Consultation Response from KC, Conservation & Design
2022/92459 Bankgate Mills, Bank Gate, Slaithwaite, Huddersfield, HD7 5DL
Conversion of former mill to form 5 apartments including extension and alterations, erection of 2 detached dwellings and demolition of outbuilding
Date Responded: 2.3.2023
Responding Officer: Sue Brooks
Responding Ref: CV 5/16

Following the previous Conservation and Design response dated 28 November 2022, amendments have been submitted. The comments below are in response to these amendments.

Proposed Second Floor Plan - 1:100

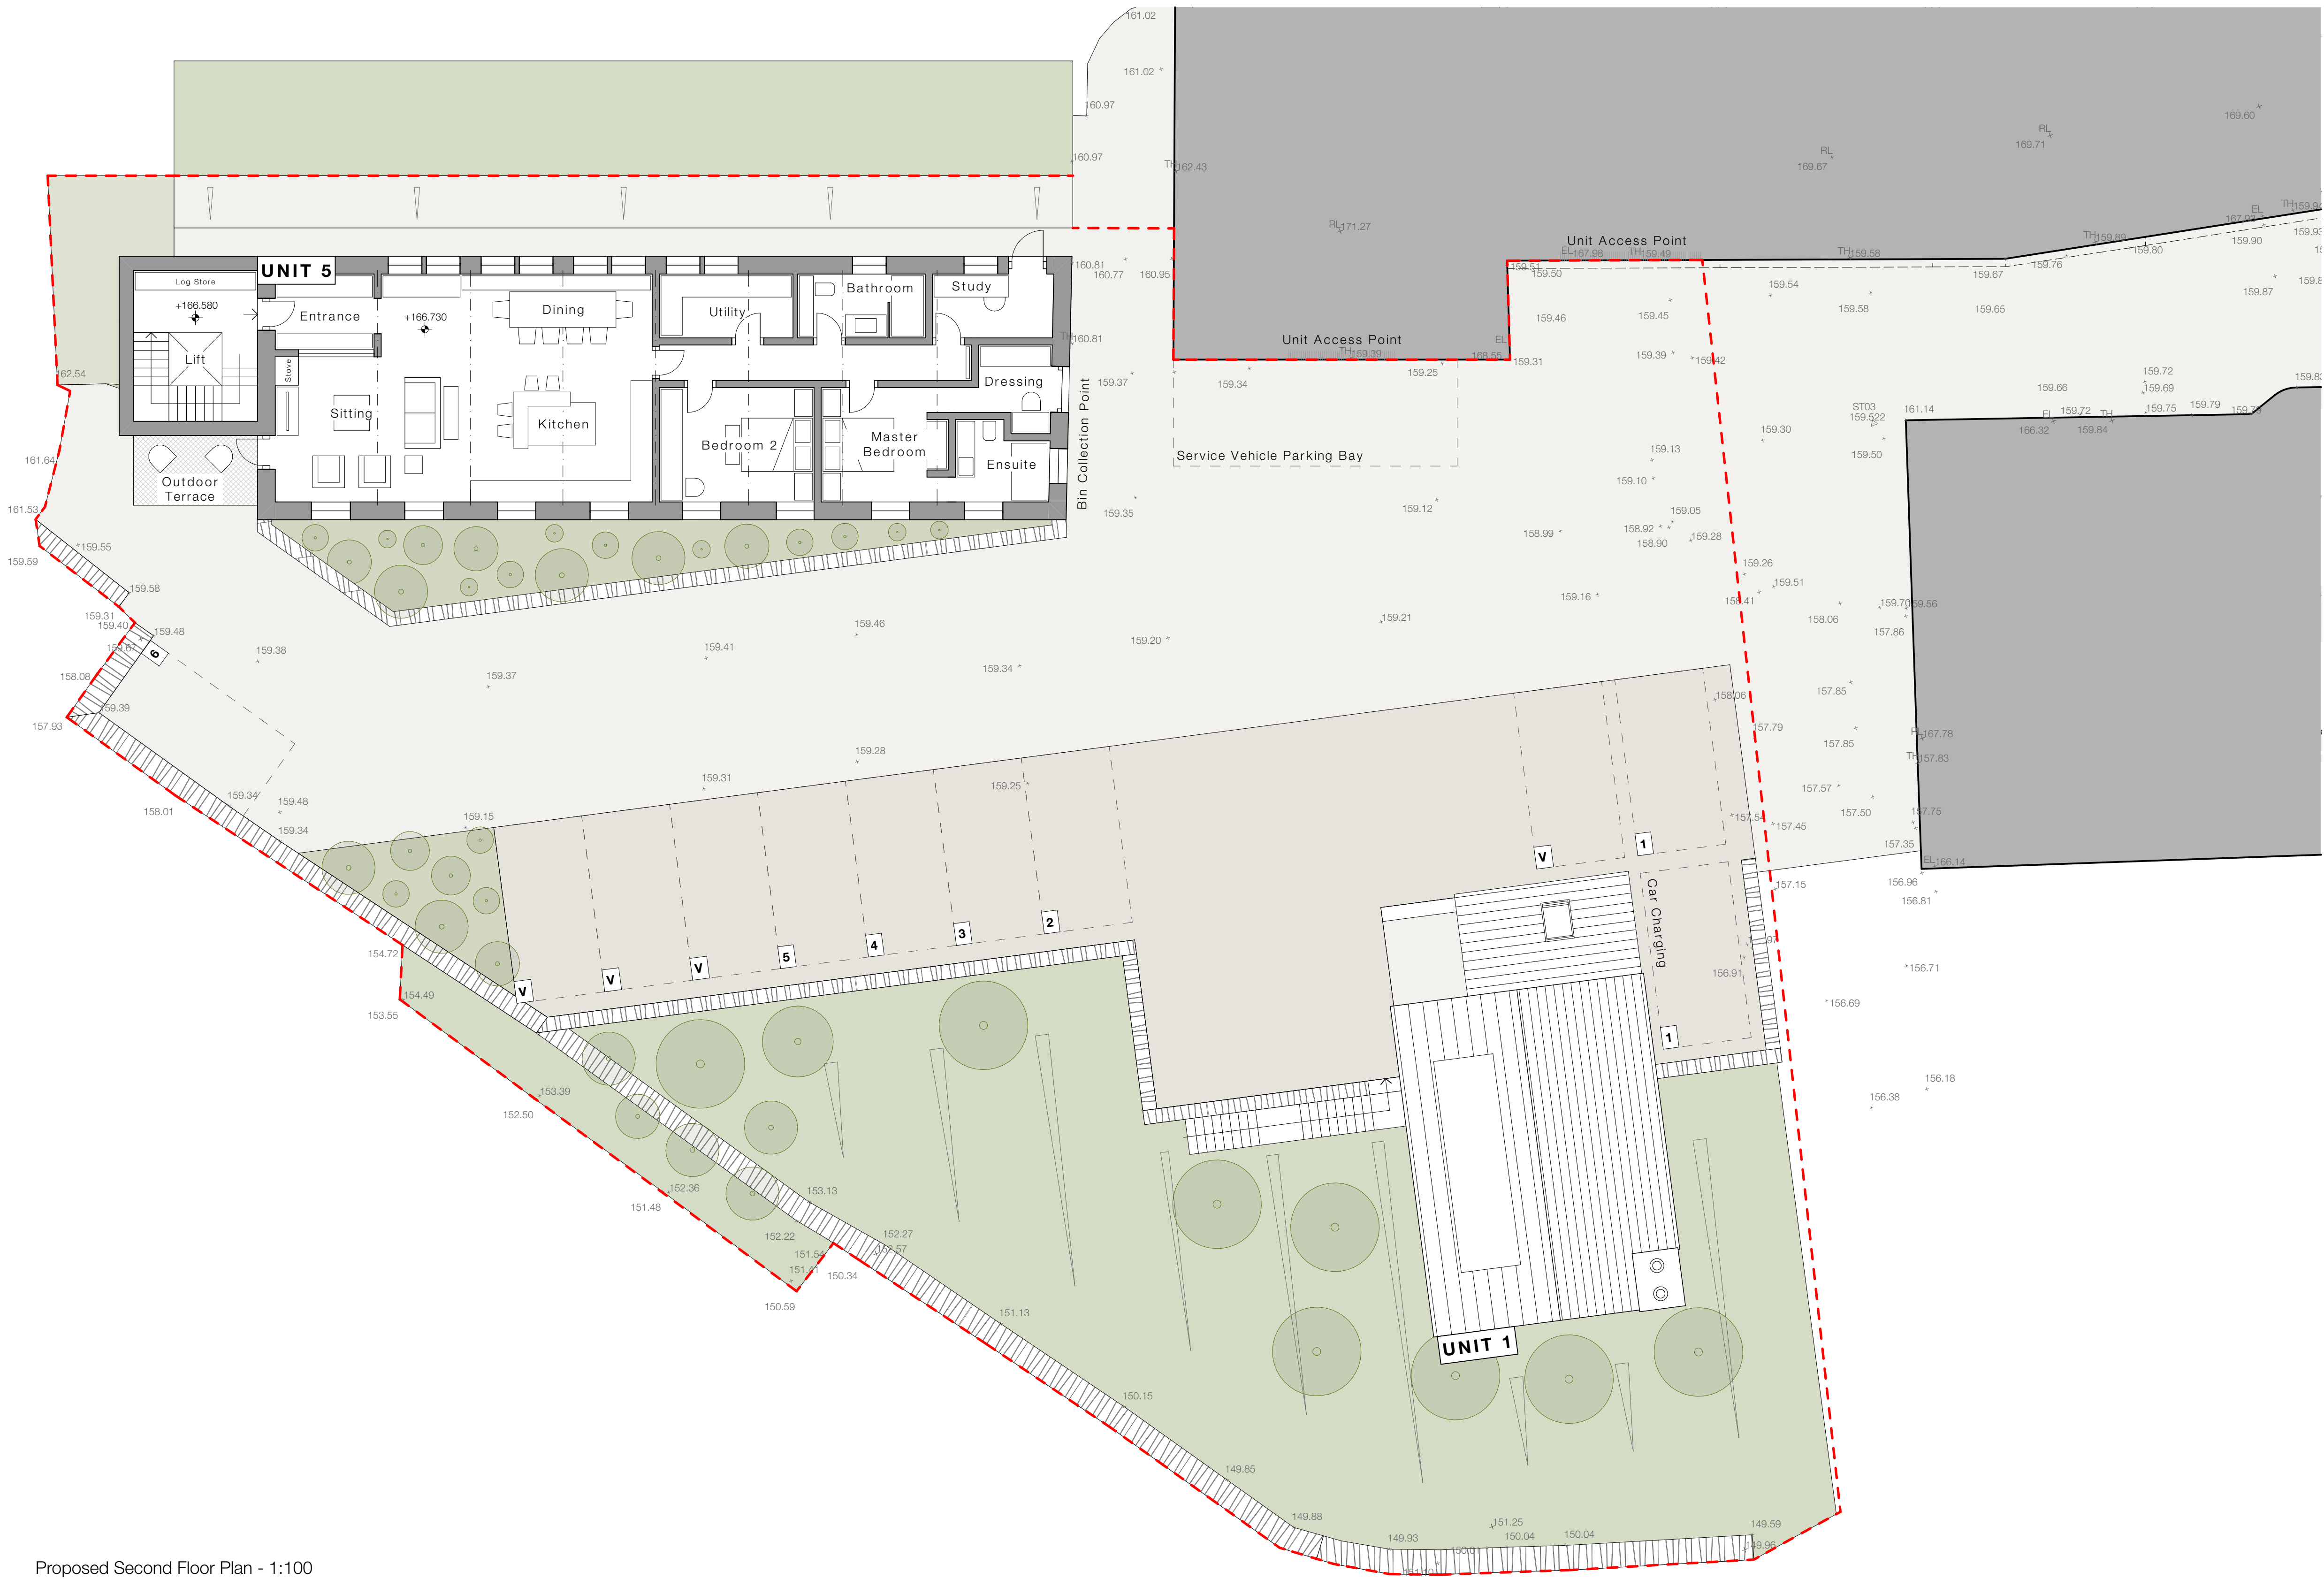
The internal space within this narrow mill building is mostly open plan on all levels, and this contributes to its significance. The proposed floor plans show extensive subdivision, particularly on the ground floor, with less subdivision on the upper three floor which provides some legibility of the historic plan form.

Internal walls throughout the building are painted coursed rubble stone with some brick infills and are of low significance. A former fireplace has been infilled on the west gable of the second floor and a fireplace surround survives on the third floor. **If the application is supported, details of proposed dry lining need to be submitted. This must be a breathable finish to prevent moisture build-up in the external walls.**
